**Plat for**  
**Lot 10-A-1, Block 13,**  
**Fairgrounds Addition**  
**Being Comprised of**  
**Lots 6 thru 8 and 10-A, Block 13,**  
**Fairgrounds Addition**  
**City of Albuquerque**  
**Bernalillo County, New Mexico**  
**October 2022**

**Project Number:** PR-2022-007112

**Re: Final Plat Review for Proposed Replat of Lot 10-A-1, Block 13 of Fairgrounds Addition, being comprised of Lots 6 thru 8 and 10-A in Block 13 of Fairgrounds Addition**

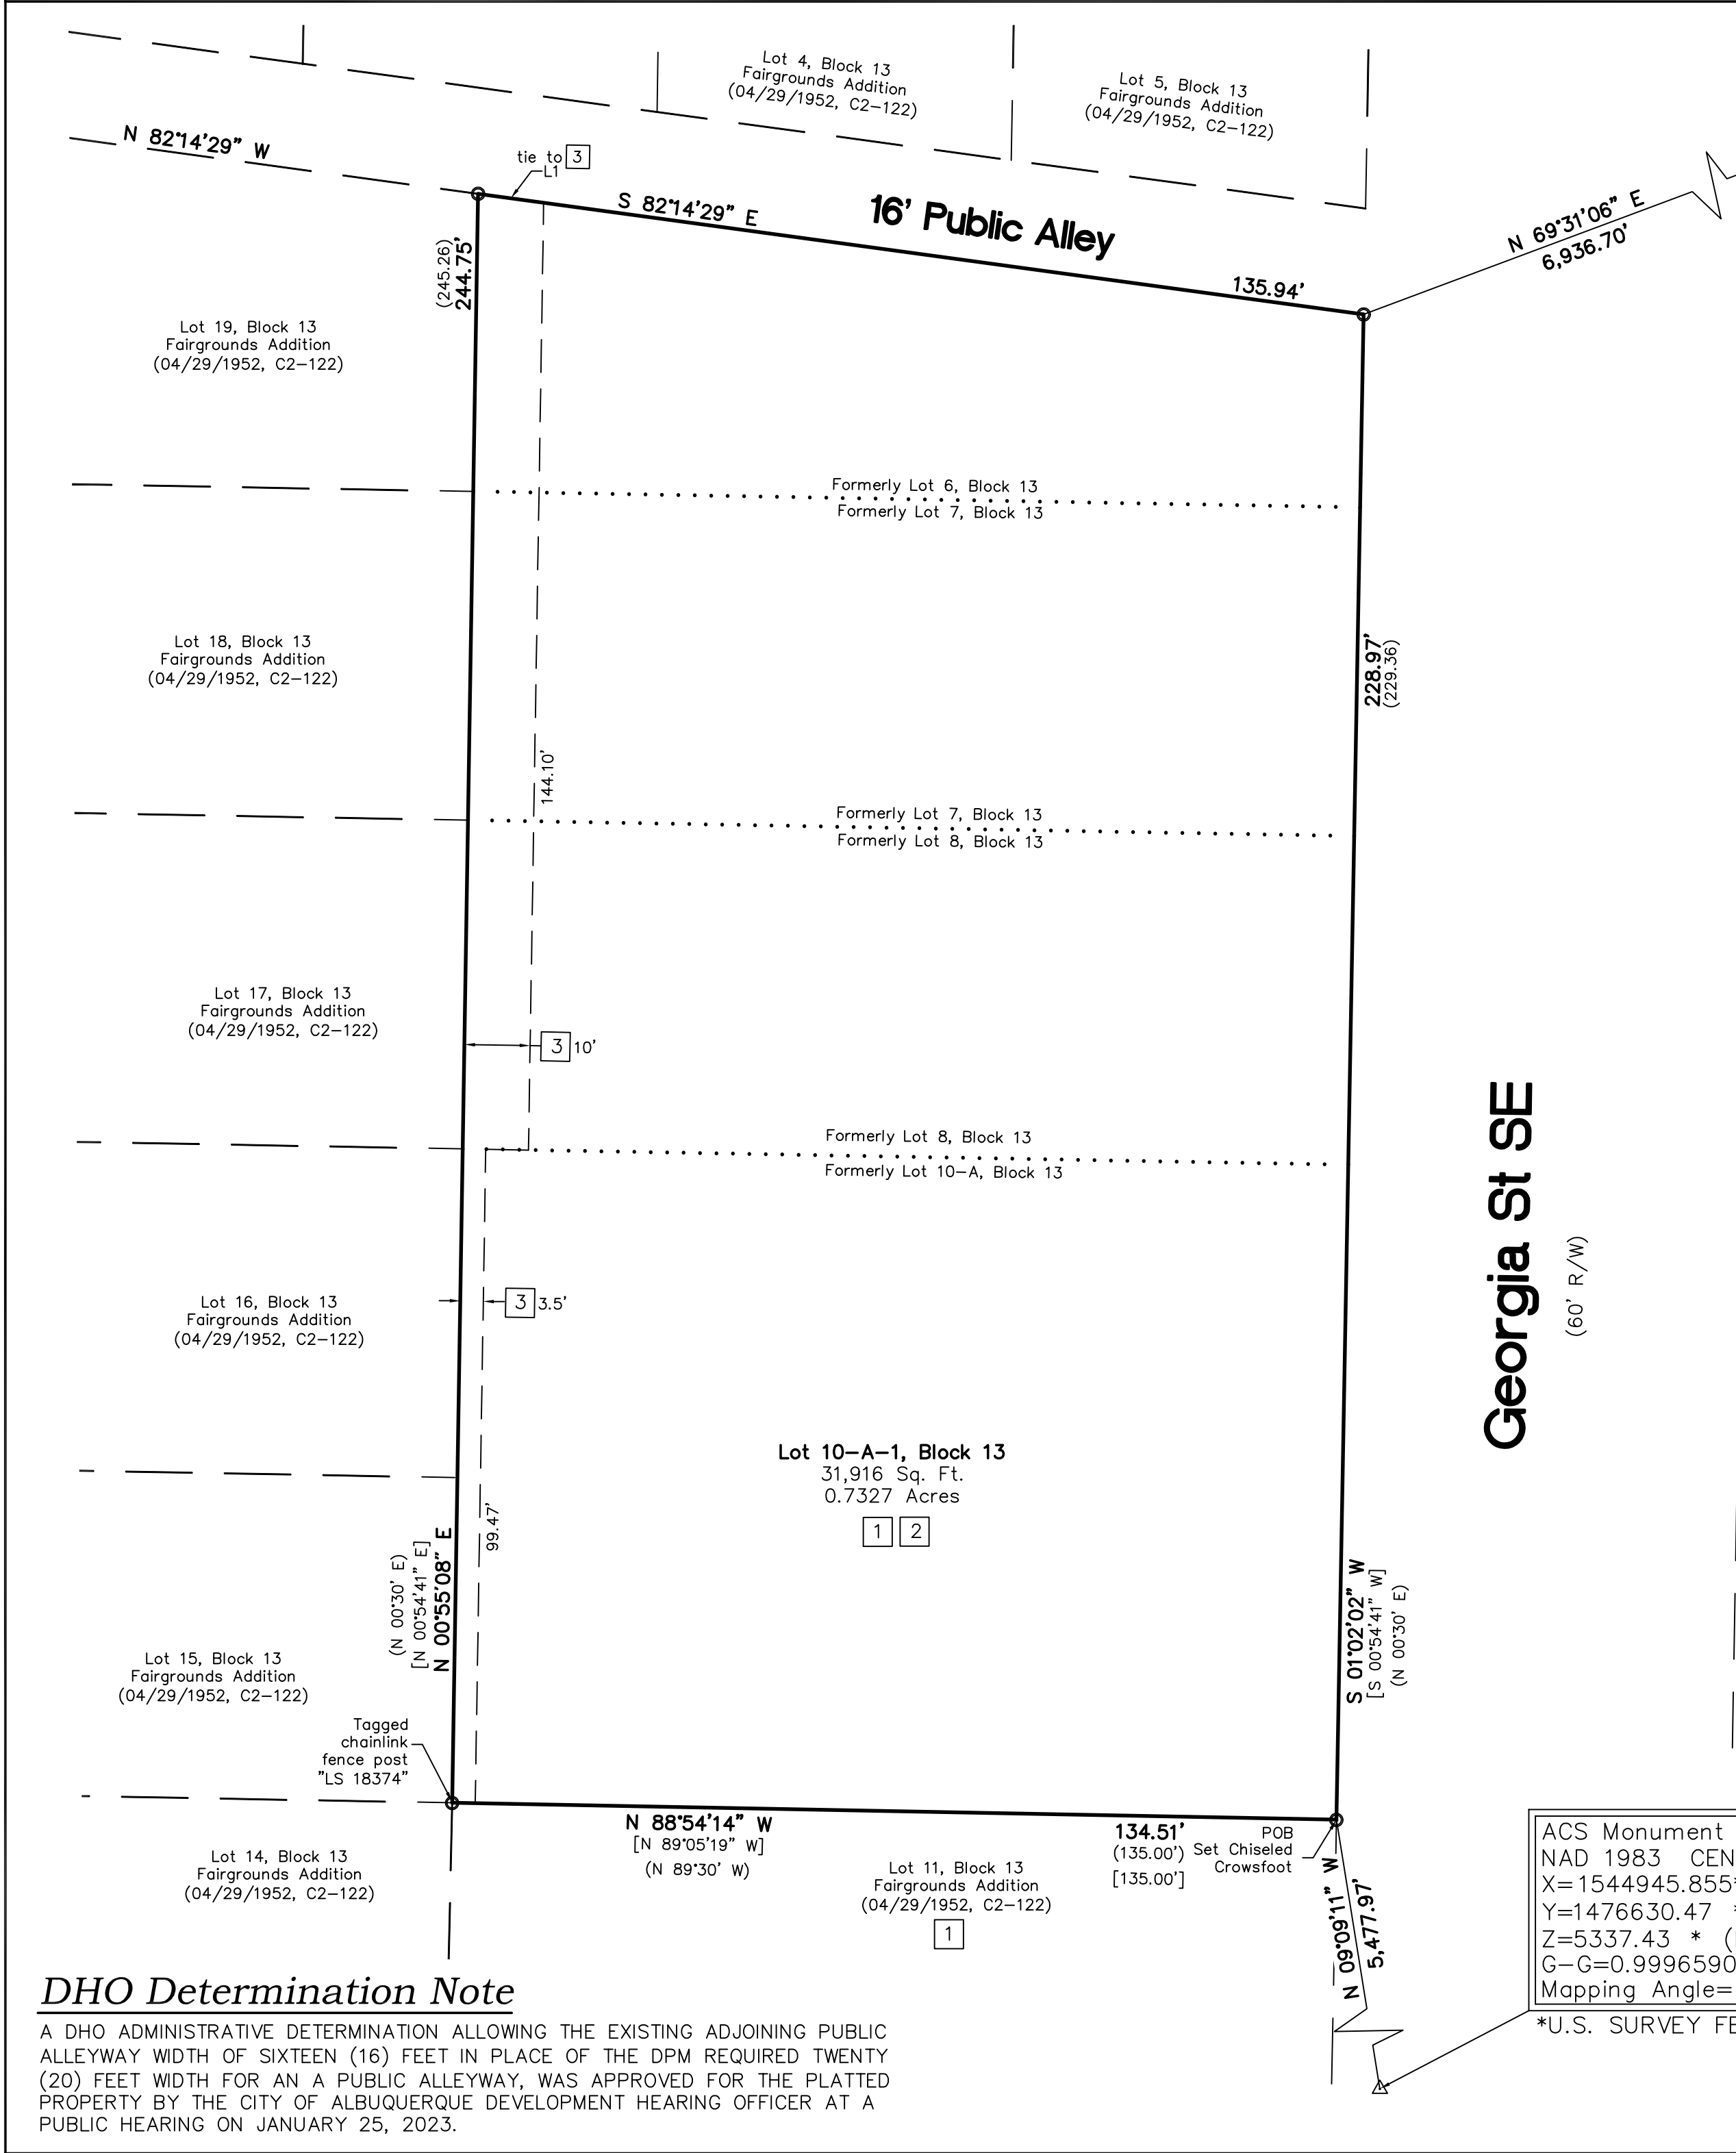
1. Show right-of-way width for Georgia Street. It shall be a minimum of 48 feet wide per DPM requirements. Also, sidewalk shall be a minimum 5-foot wide width. Provide exhibit showing right-of-way, sidewalk, and street width. Right-of-way dedication may be required.

2. The alleyway width shall be a minimum 20-foot wide width. Provide this information. Provide curve for the property corner between alleyway and Georgia Street that should take into account public infrastructure and sight distance.

3. Ensure all fencing is located outside of public right-of-way. Also show fencing within the exhibit. These may also present sight distance concerns.

Noted, right-of-way is 60 feet wide per record plat and field evidence. There is sufficient space to widen sidewalk once fencing and walls are relocated (see 3, below)

We request an administrative decision to allow the existing 16-foot alleyway width, given the buildings and infrastructure in place near the right-of-way line. All public infrastructure is located within the Georgia right-of-way, so dedication of right-of-way is unnecessary here.

As for the fencing and walls fronting Georgia, they will be relocated per ex-parte discussion with Mr. Ernest Armijo and our client Linda Nguyen. The Viet. Buddhist Congregation has an encroachment agreement (4/7/1997, Doc. No. 97034455) for their property, but was willing to relocate to provide the ADA minimum sidewalk.
